The application seeks permission for the erection of a proposed single-storey side extension and first floor extension to the existing chalet bungalow, with associated adaptation of the frontage to provide access for the elderly (20/00857/FULH). The Case Officer recommends to the Development Management Section Head that the application be **refused** as set out in the report.

Client	MR SACHIT VINOD.	Site	273 GAMMONS LANE, WATFORD, WD24 5JP.		
Project	SINGLE STOREY SIDE, REAR AND FIRST SIDE EXTENSIONS.	Title	PROPOSED FRONT, REAR, SIDE AND PARTY WALL ELEVATIONS.		
Scale	1:100 @ A3	Date	14/06/2021	Drawn by	SSC
				Drg. No	273GAMMONS/PA4
				Revision	A

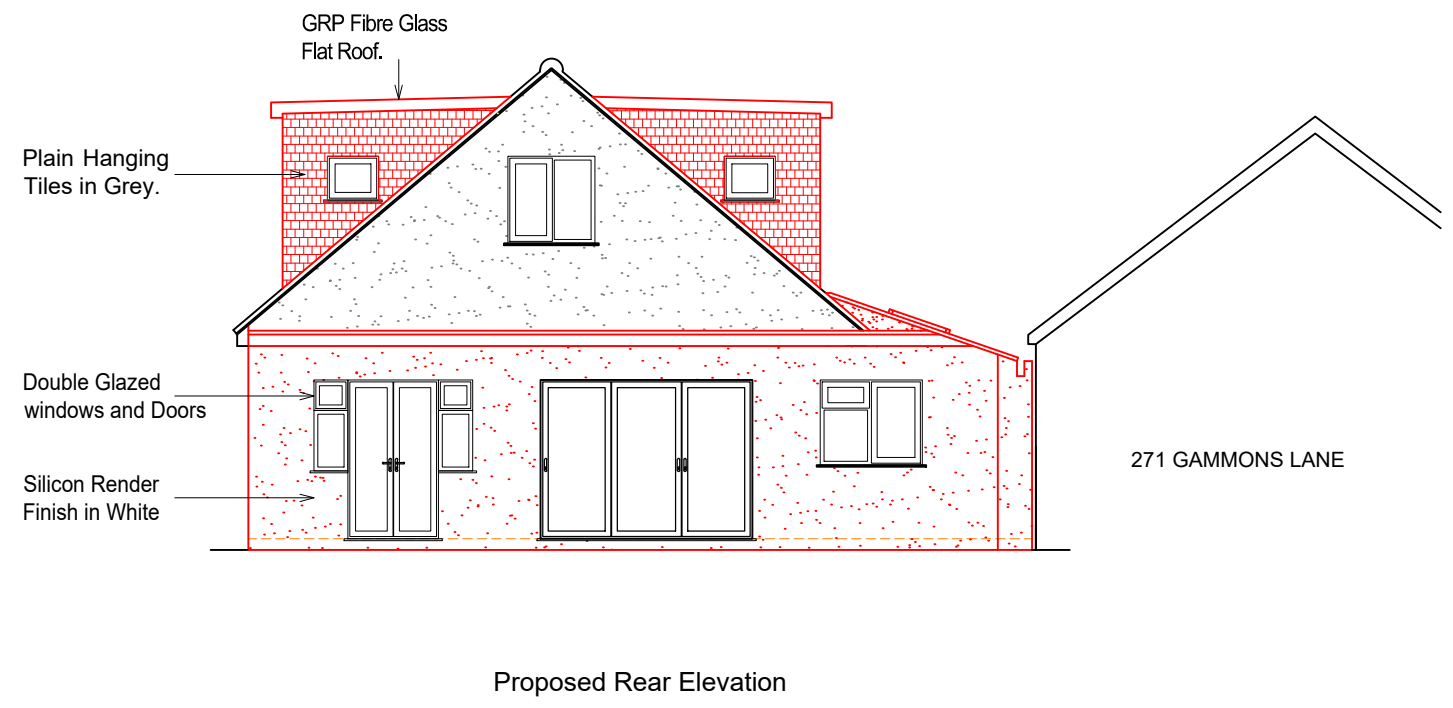
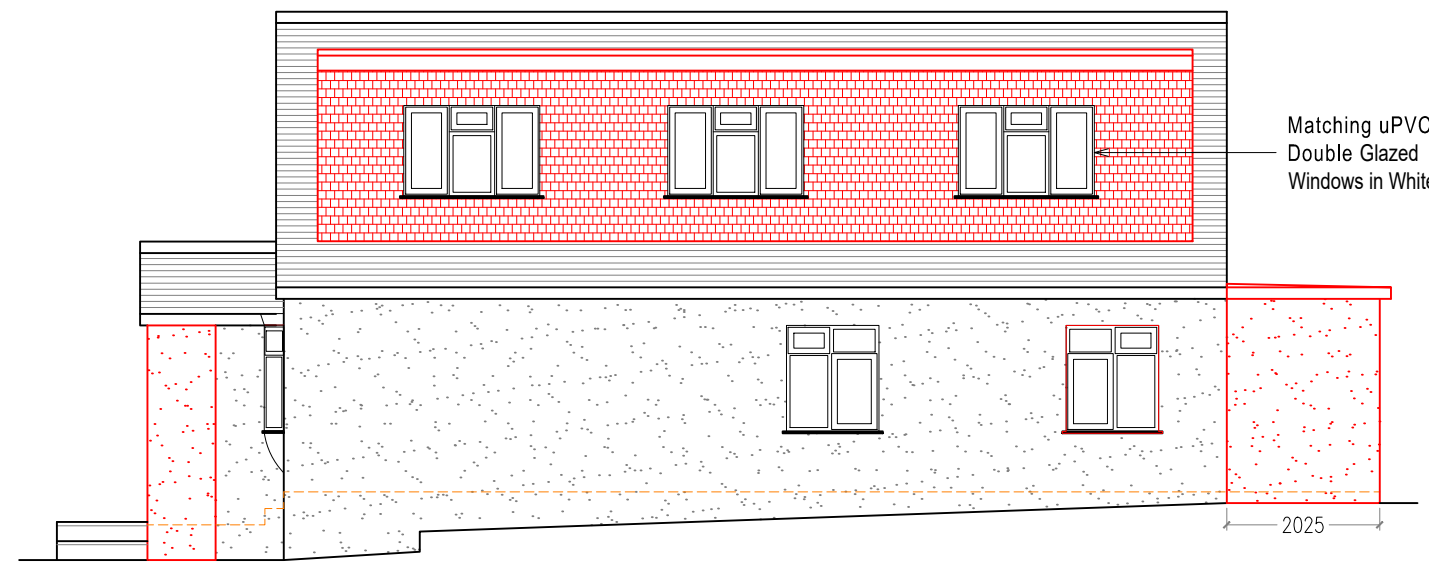
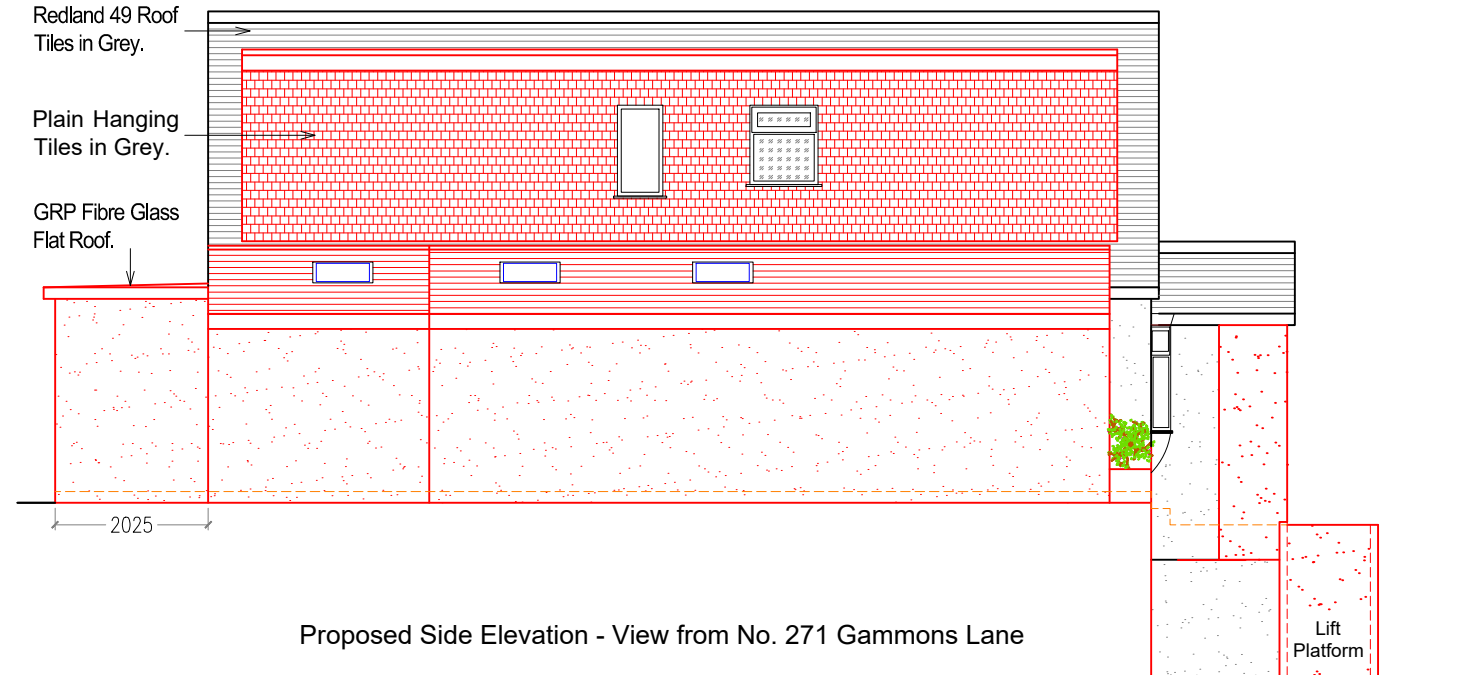
The proposed single-storey side extension would replace the existing attached garage structure and would provide for increased space to the living room and kitchen area. The proposed roof form of the side extension is shown to be sloping roof pitch with eave height to correspond to the eave height of the neighbouring property’s (No. 271) main roof. There is an existing garage structure to the eastern side of the application property and so there already exists an element of built form to the side of the dwelling which is absent from the other chalet bungalows on this row. The principle of its replacement with a single-storey side extension is considered acceptable. Notwithstanding, the Council’s Residential Design Guide states that side extensions should appear subordinate in terms of their height, scale and bulk and set back at least 1m from the principal elevation of the host dwelling. The proposed side extension would not be set back but, instead, would be flush to the principal building line of the host dwellinghouse, so would not read as a subordinate addition.

The proposals also seek permission for the addition of a first floor extension. This would have the effect of creating a two-storey dwellinghouse structure from the original chalet-style bungalow with a dual-pitched roof and front and rear gable ends. The proposed first floor extension would add a degree of bulk and massing which is considered to be out of proportion to the original dwelling. No.s 271 – 279 Gammons Lane are a row of similarly proportioned detached chalet-style bungalows which together give consistency to the character and appearance of this part of Gammons Lane, in terms of their scale, design and setting within their individual plots. The proposal would present as a large two-storey dwellinghouse, which would appear out of character in the street scene. As there is not a minimum 1m set-in from the side boundary on both sides of the property, the development appears cramped in the context of its immediate neighbours, particularly when combined with its proposed height. Overall, it is considered that the proposed replacement first-floor extension would detrimentally alter the character and appearance of the host property and would result in a prominent and incongruous form of development.

The proposed development includes two windows to each side facing elevation at first floor level. These windows would serve the proposed staircase, dressing room and two bathrooms. There are no windows to the neighbouring properties which would be affected by these proposed windows. The proposal would result in the net addition of one window to the rear elevation at first floor. The existing rear-facing window serves a bedroom and the proposed floorplan would similarly be bedrooms at the rear of the dwelling. Consequently, it is considered that the proposed development would not harm the amenities of either neighbouring resident materially beyond that which currently exists.

The proposal would add another storey to the present dwelling, in effect creating a two-storey dwellinghouse on the site. The outlook of those properties to the rear along Burrows Close, particularly No.1, will differ from existing, but it is not considered that No.1 would be materially closed in by the proposals. A degree of overlooking would result towards the rear of No.1 Burrows Close by virtue of the proposed addition of a second floor level with windows to the rear elevation. The separation distance between the rear-facing building line of the application property and No. 1 Burrows Close, the closest neighbouring property to the rear, is approximately 17m, and the distance between the application property and the property boundary is approximately 11m which accords with the stipulations of the RDG. With regards to any resulting loss of privacy and overlooking to No.1 Burrows Close to the rear of the site from the application proposals, it is not considered that the proposals would result in a loss of privacy and overlooking to a materially harmful extent.

- (1) The proposed development by reason of its siting, design, bulk and massing would introduce an over-dominant and cramped form of development, out of keeping with the character of development within the street scene detrimental to the visual amenities of the locality. This would be contrary to Policy UD1 of the Watford Local Plan Part 1 Core Strategy 2006-31.
